Planning and Development Department
Lee D. Urban, Director

June 12, 2007

RE: Final Site Inspection, (Project # 2006-0087), (CBL 382A D 021001)

GRADING PLAN
OF:
LOT 1 AUBURN ESTATES
LONGVIEW DRIVE
PORTLAND, MAINE
FOR:
BRUSH AND HAMMER INC.
110 LESTER DRIVE
PORTLAND, MAINE 04103

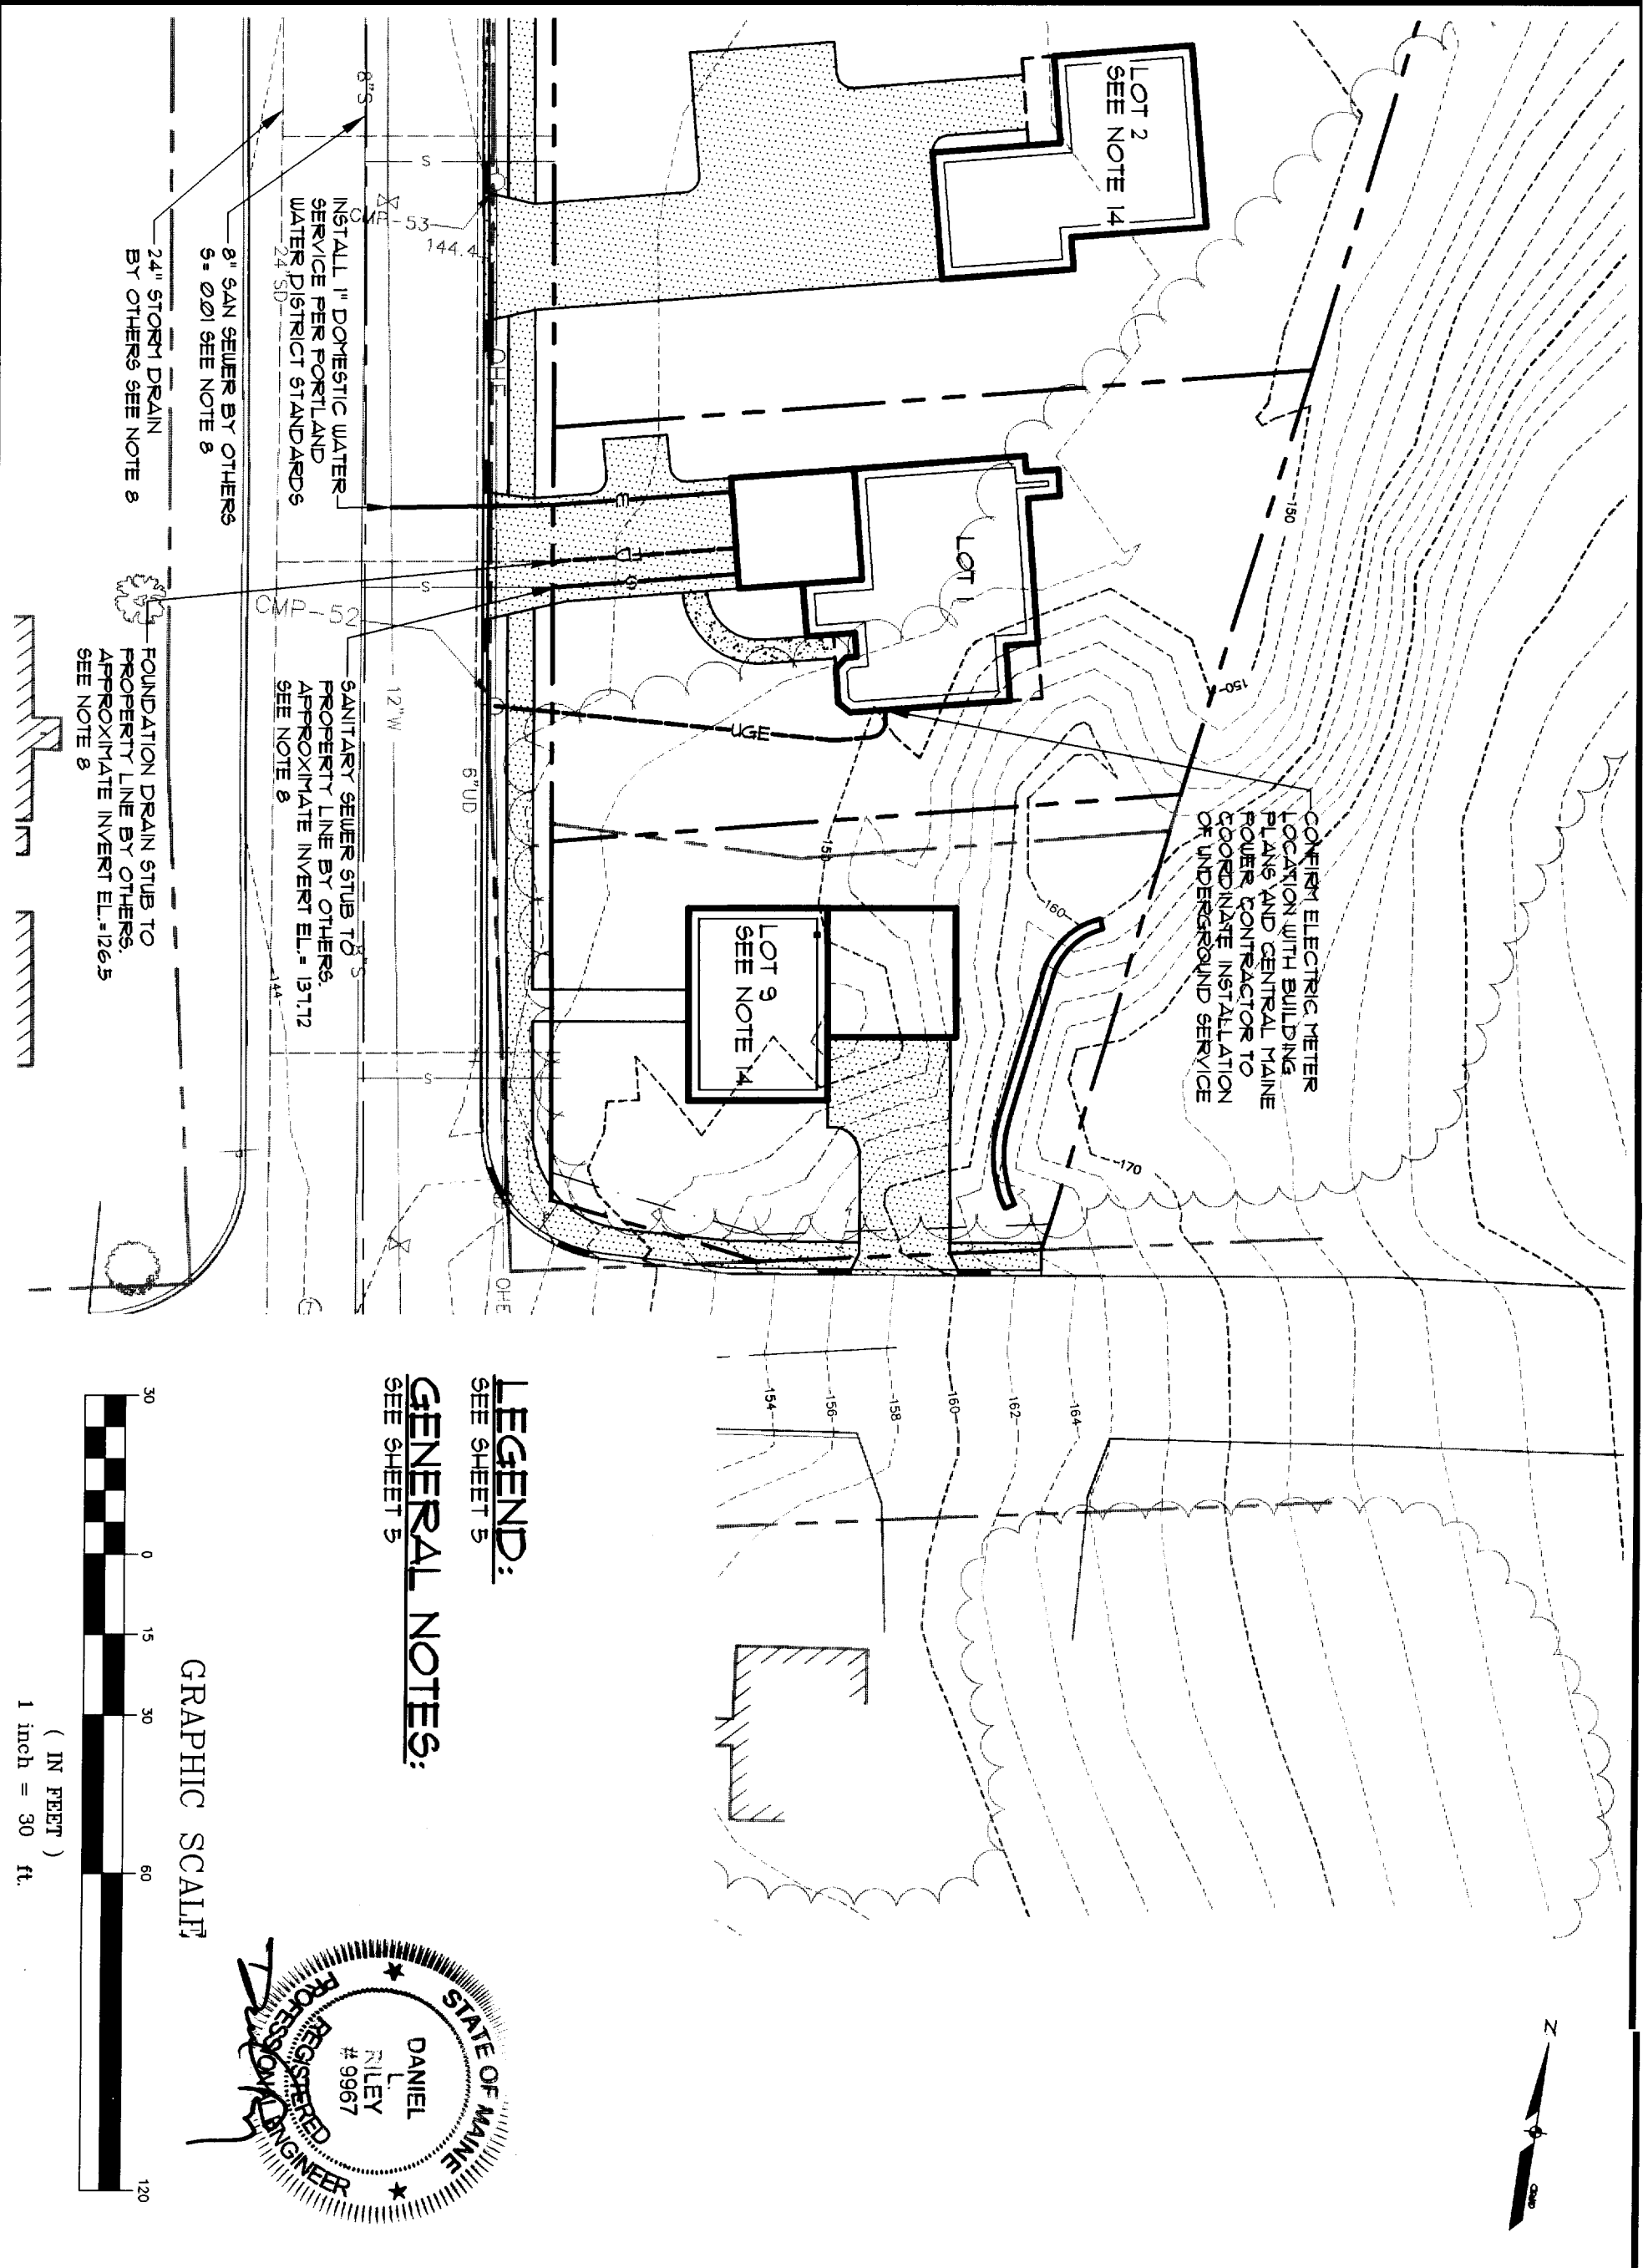
1. Final grading per the approved site plan; the grade along both sides and the front of your house appears to be pitched toward the house causing water to drain toward the foundation. Per the approved site plan, the grade should be pitched away from the foundation toward the street. This must be corrected.
2. Loaming and seeding of all disturbed areas,
3. Two (2) City of Portland approved species and size trees must be planted on your street frontage. The trees that have been planted are less than the minimum accepted standard. The trees must be a minimum 2 to 2 ½ caliper in size.
